From: Rebekah Morgan
Sent: 27 January 2023 21:05
To: Rebekah Morgan
Subject: FW: 22/03049/out - Station Road, Kirtlington

From: Mundy, Ben - Oxfordshire County Council < >
Sent: 21 December 2022 16:05
To: Daniel Moore <
Cc: Rebekah Morgan < **Subject:** RE: 22/03049/out - Station Road, Kirtlington

Parameter Plan - Access and Movement | Lince Lane, Kirlington

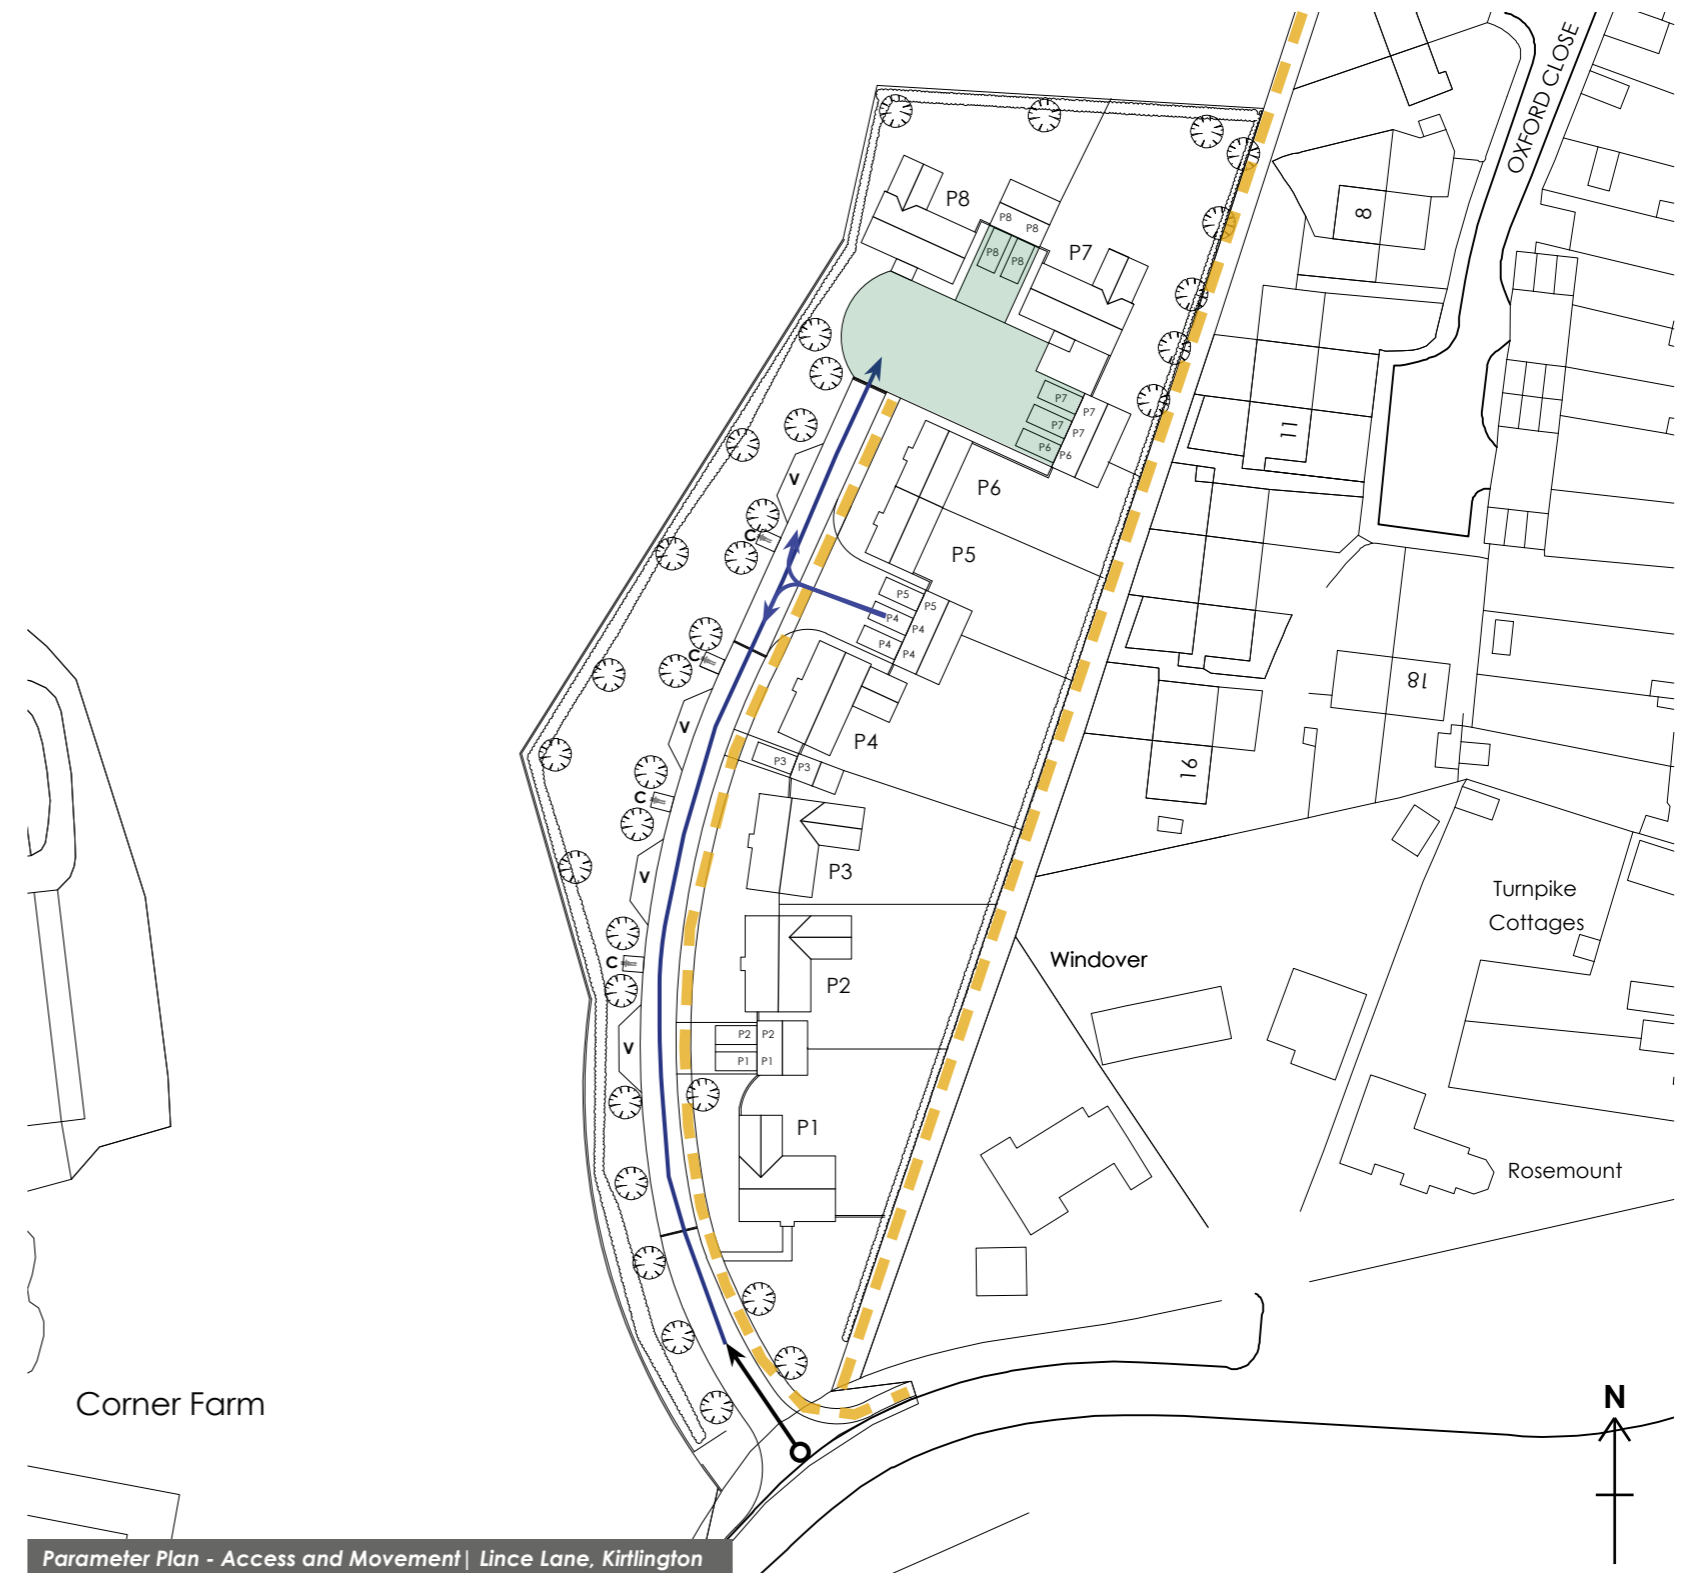
- The tracking overhangs onto the verge and visitor cycle parking bays.
- I think to ensure the maximum safety of this access, the extension of the 20mph limit should be implemented. I know from personal experience that vehicle still carry speed in excess of the speed limit in both directions surrounding this access point, I do not believe the speed surveys are unnecessary.
- I also made an error in referencing the cycle parking, our updated standards state that dwellings should have 2 spaces per bedroom in line with LTN 1/20 as apposed to 1 space per dwelling.
